CITY OF ALBUQUERQUE

May 19, 2023

**Re: Albuquerque ER
8220 Montgomery Blvd. NE
30-Day Temporary Certificate of Occupancy
Transportation Development Final Inspection
Engineer's Stamp dated 11-22-21 (G19-D004D)
Certification dated 05-01-23**

SP-1

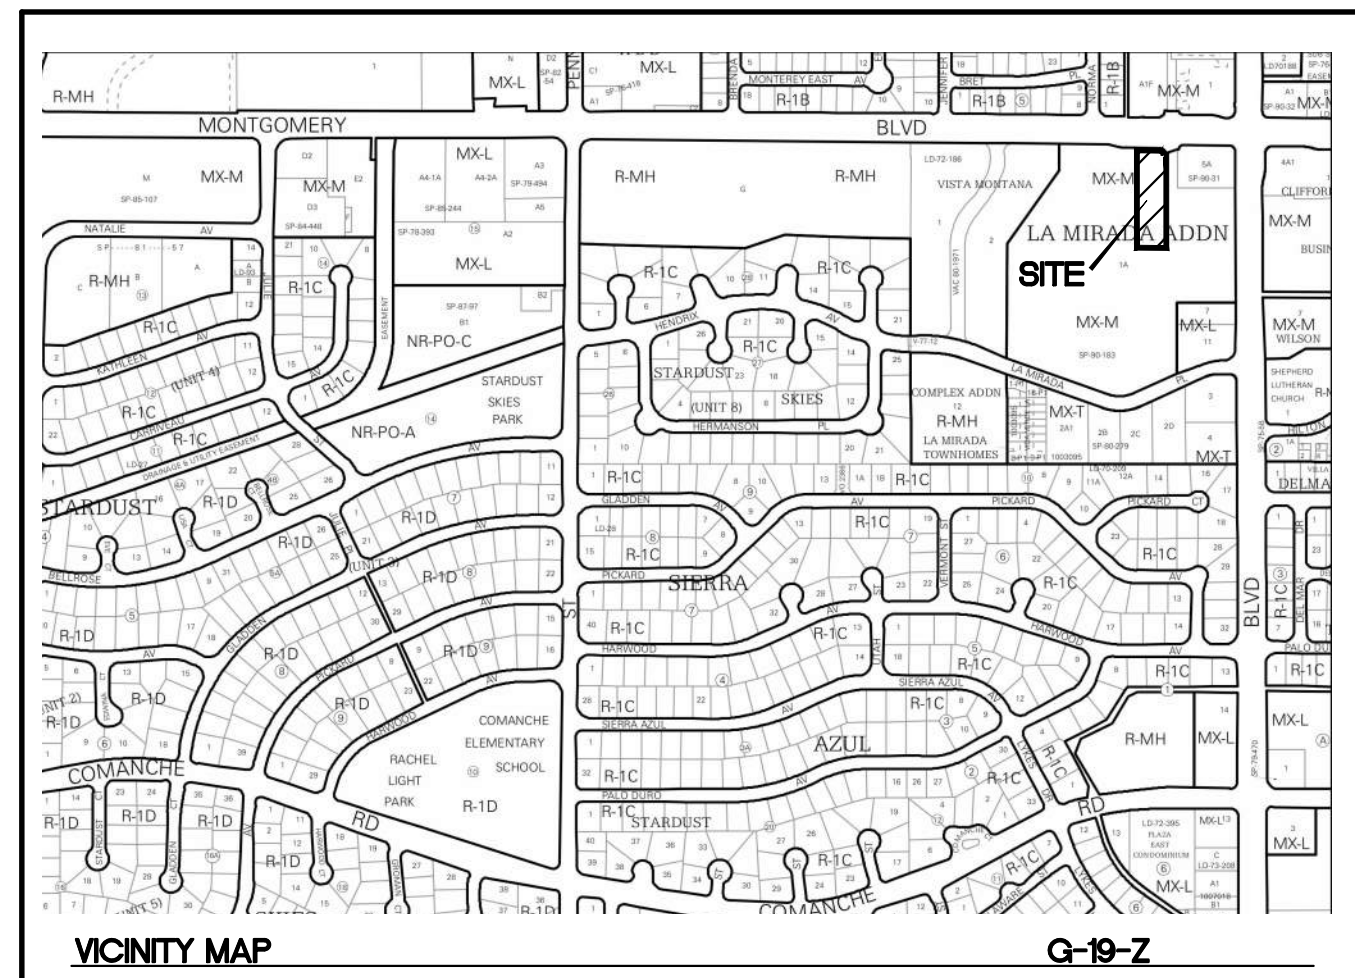
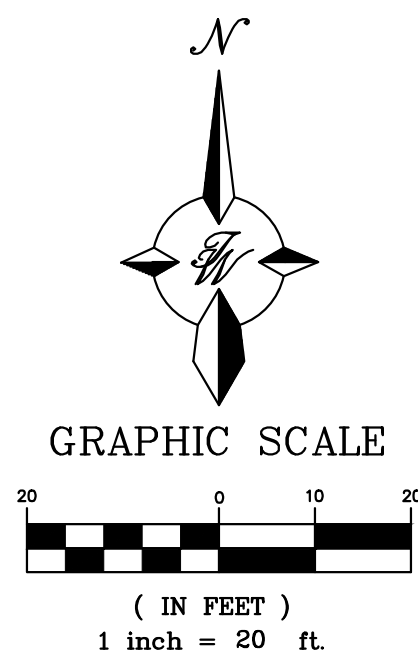
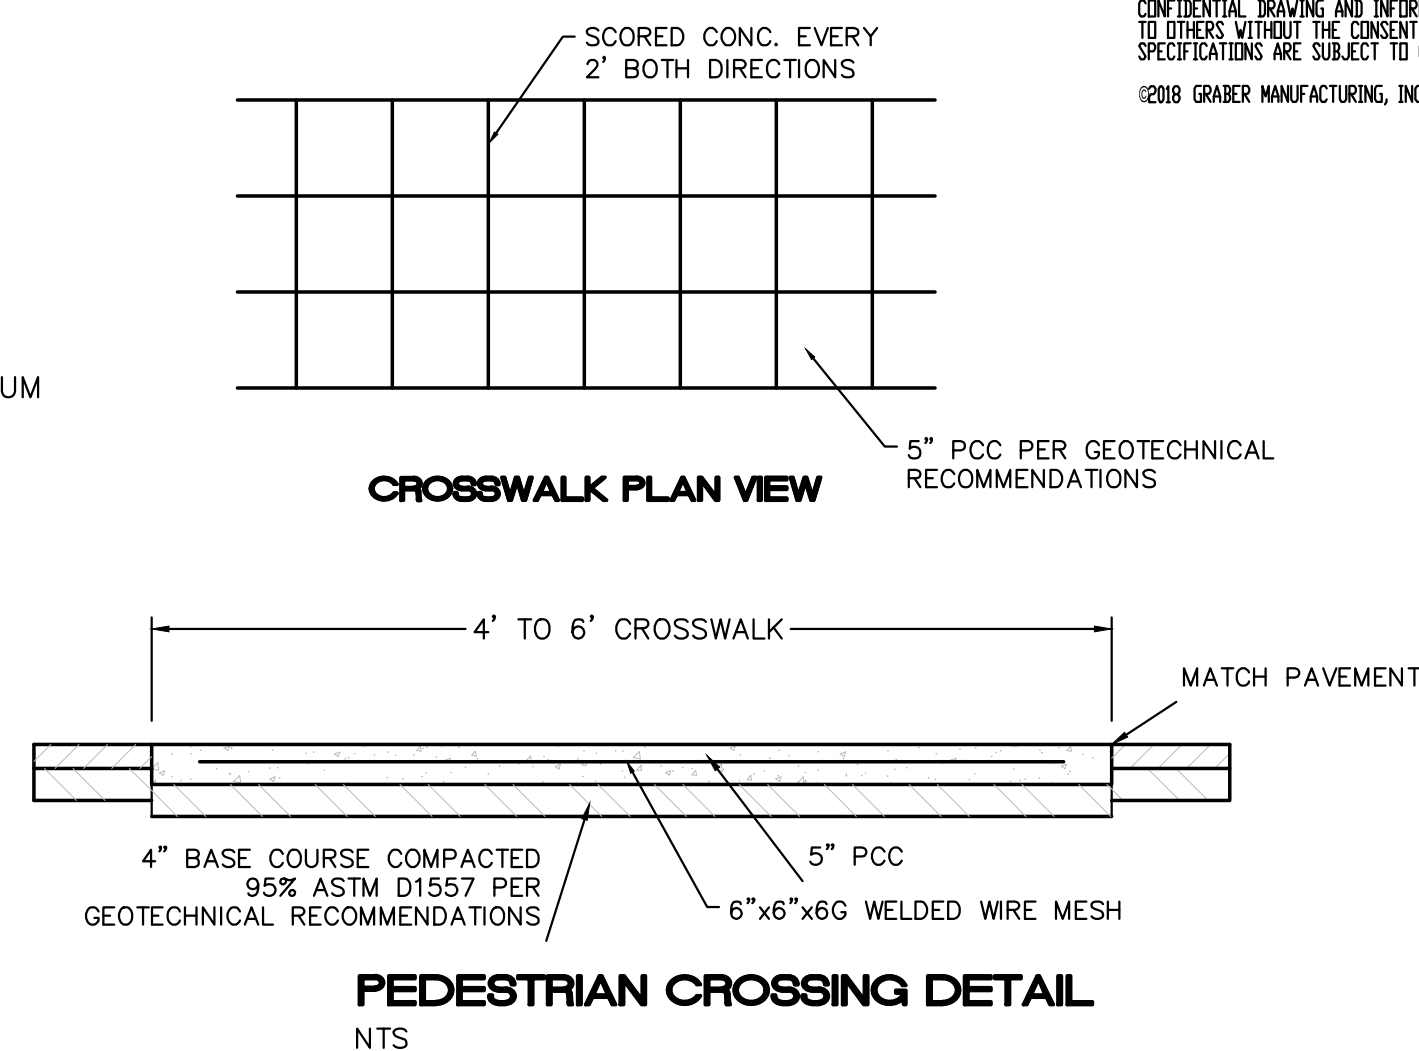
- Please provide Motorcycle parking per approved site plan keynote 5.
- Provide Bike Rack per approved site plan keynote 12.
- Provide 6' pedestrian crossing per approved site plan keynote 11.
- Condition of release final CO, please provide approved/ recorded final plat.
